**CITY OF PORTLAND, MAINE  
DEVELOPMENT REVIEW APPLICATION  
PLANNING DEPARTMENT PROCESSING FORM**

Address of Proposed Site 315 Cumberland Ave

**TO:** Richard Knowland, Senior Planner  
**FROM:** James Seymour, Acting Development Review Coordinator  
**DATE:** July 1, 1996  
**RE:** Cumberland Avenue Parking Garage Site Plan - August Corp.

I have reviewed the plans and details associated with the site plan application for the Cumberland Avenue Parking Garage by August Corporation and provide the following comments:

Site Improvement Plan

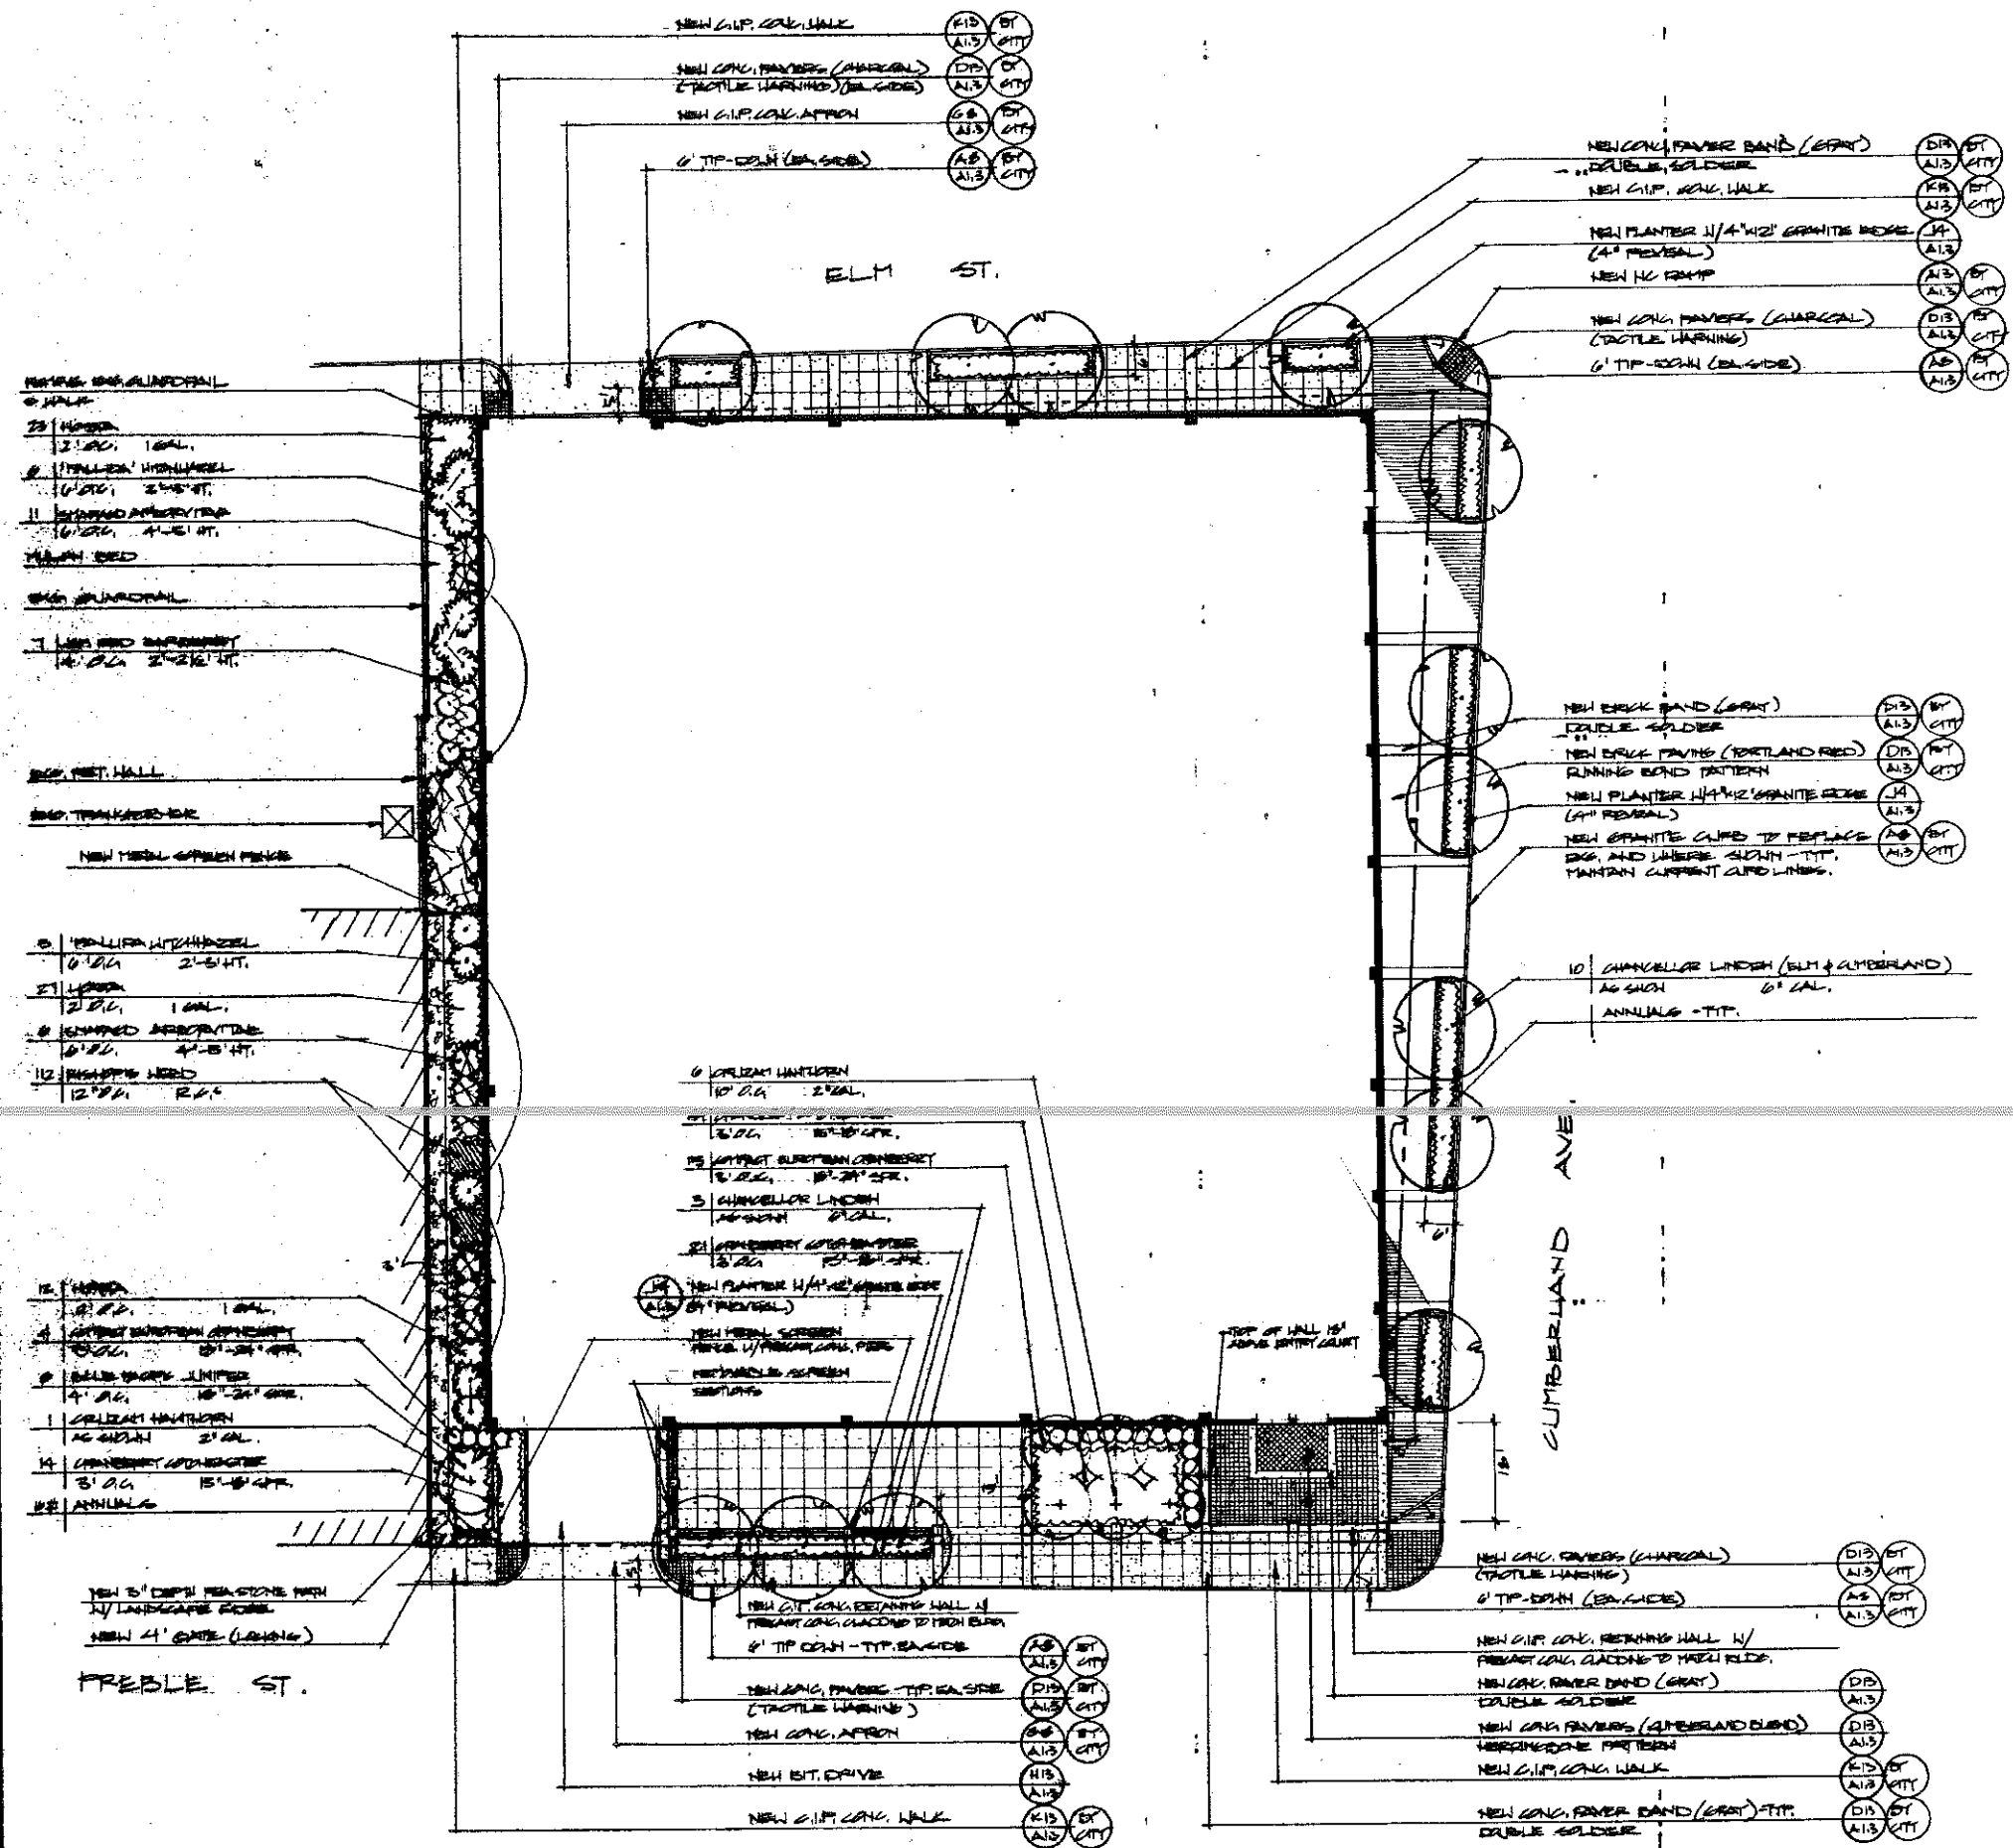
2. Site Improvement Plan

A. The handicap ramp and sidewalk corners as shown on the plan at the location of Elm Street and Cumberland Avenue should not be designed with curved tipdowns. Instead the ramp shall be designed the same as the ramp on the corner of Preble Street and Cumberland Avenue.

B. A note shall be added to the detail for underdrain to specify pipe material. Also, the location of the underdrain connection shall be shown. I strongly suggest that based on the possibility that contaminated soils may exist, according to S.W. Coles report, the foundation drain may transport some of the oil contamination to the stormdrain system. If the foundation drain is connected to the treatment system it could enhance the groundwater and stormwater discharge.

D:\98-216\ACAD\101 Mon Jul 1 08:36:44 1996

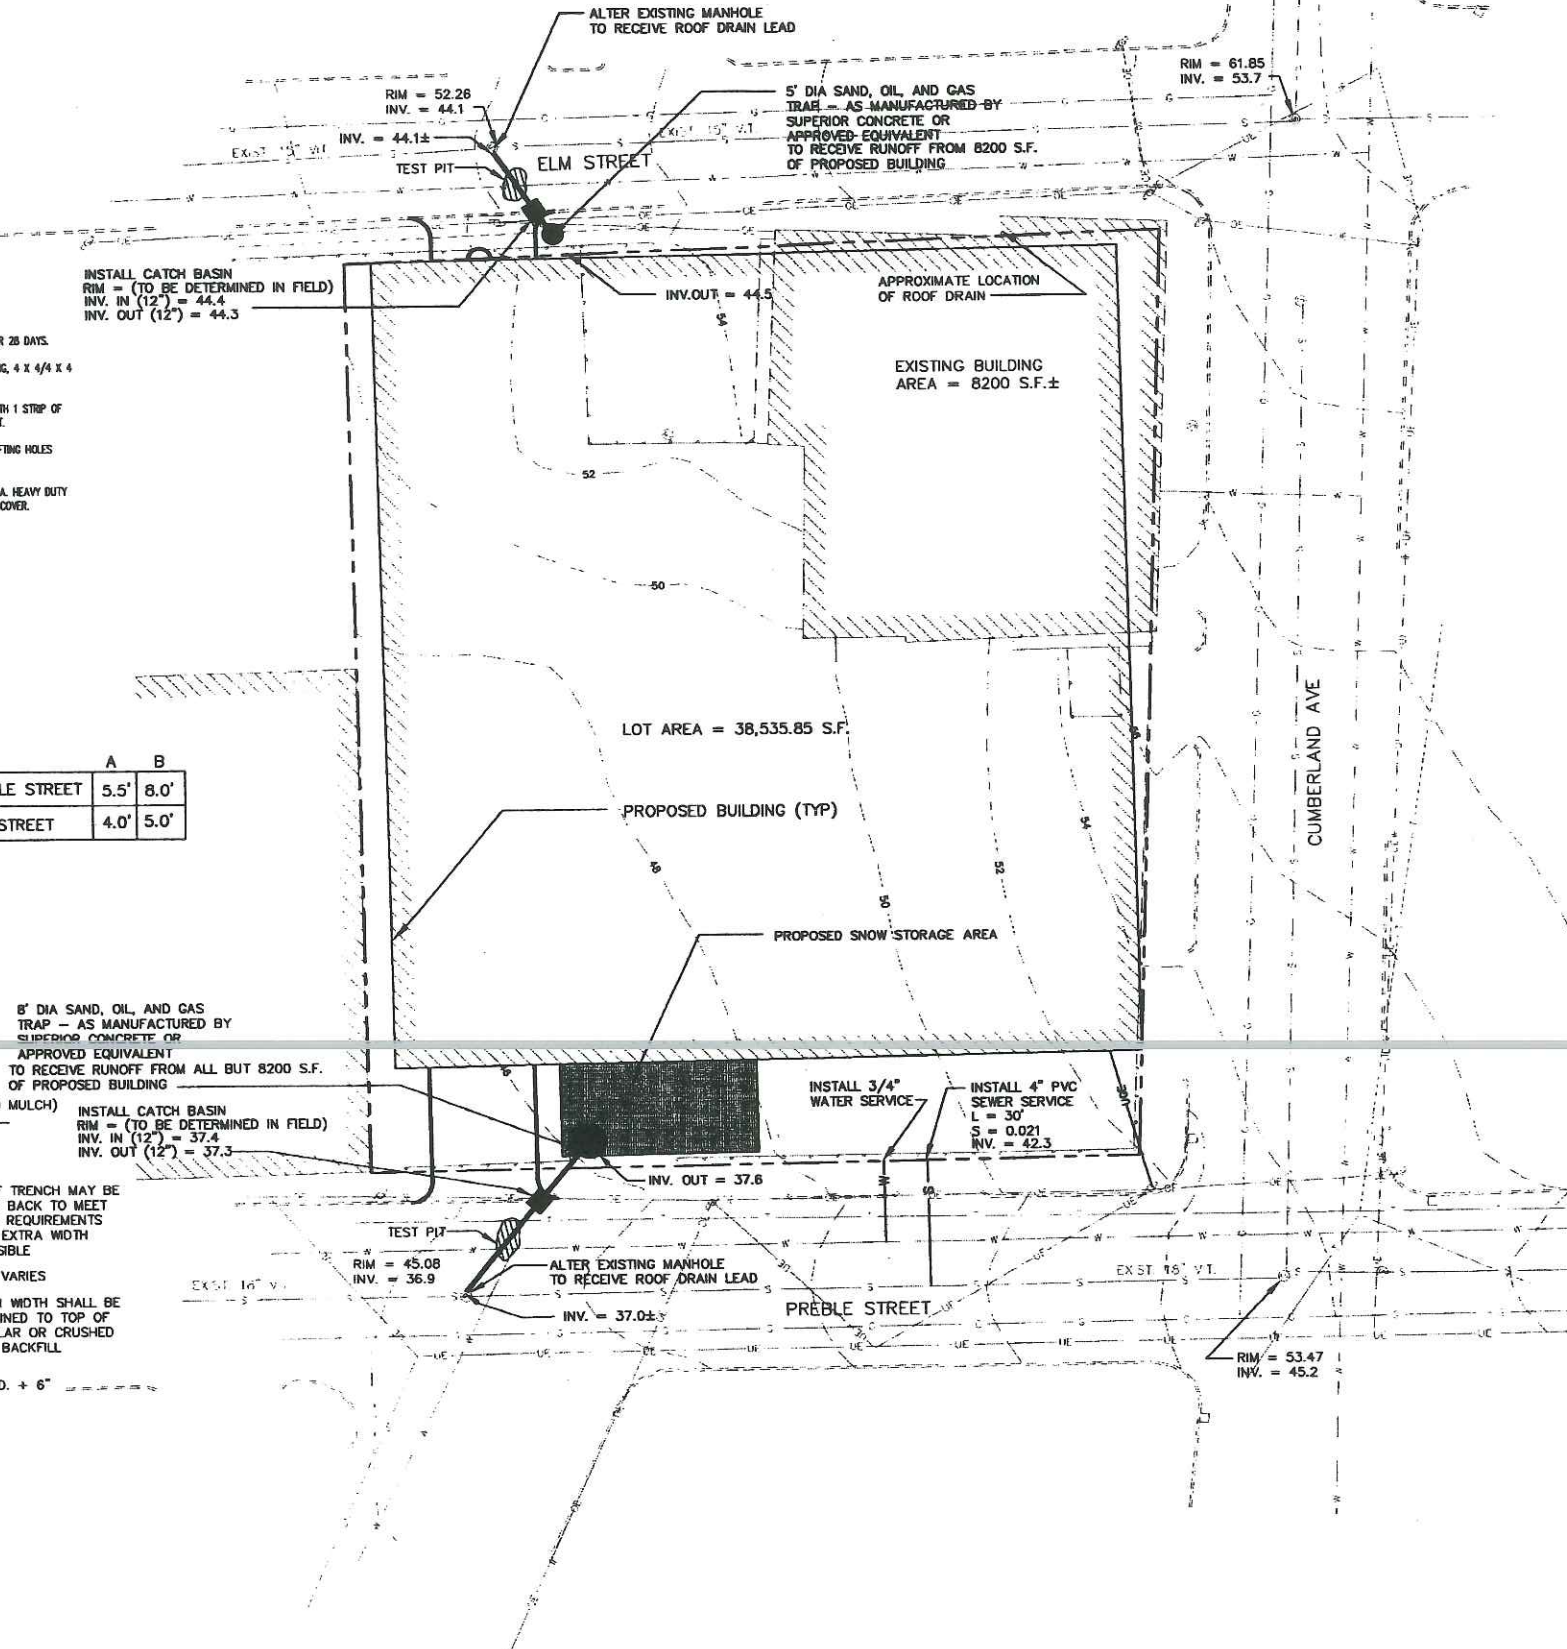
1. Drainage Plan

The locations of the street catchbasins shall be further away from the handicap ramps such that standard catchbasin inlet "headstone" can be installed.

Standard City of Portland details for Precast Concrete Catchbasin Type "E", Typical A-4 Catchbasin Stone Detail, and the Typical Pavement Grading on Slopes for Catchbasin and Inlet.

A catchbasin was to be added in the area designated for snow storage. No catchbasin was indicated on the plan. I've spoken with the consultant who may modify the larger 8' oil/grit separator to also function as a catch basin. A detail of the modification or the additional catchbasin shall be added to the Drainage Plan.
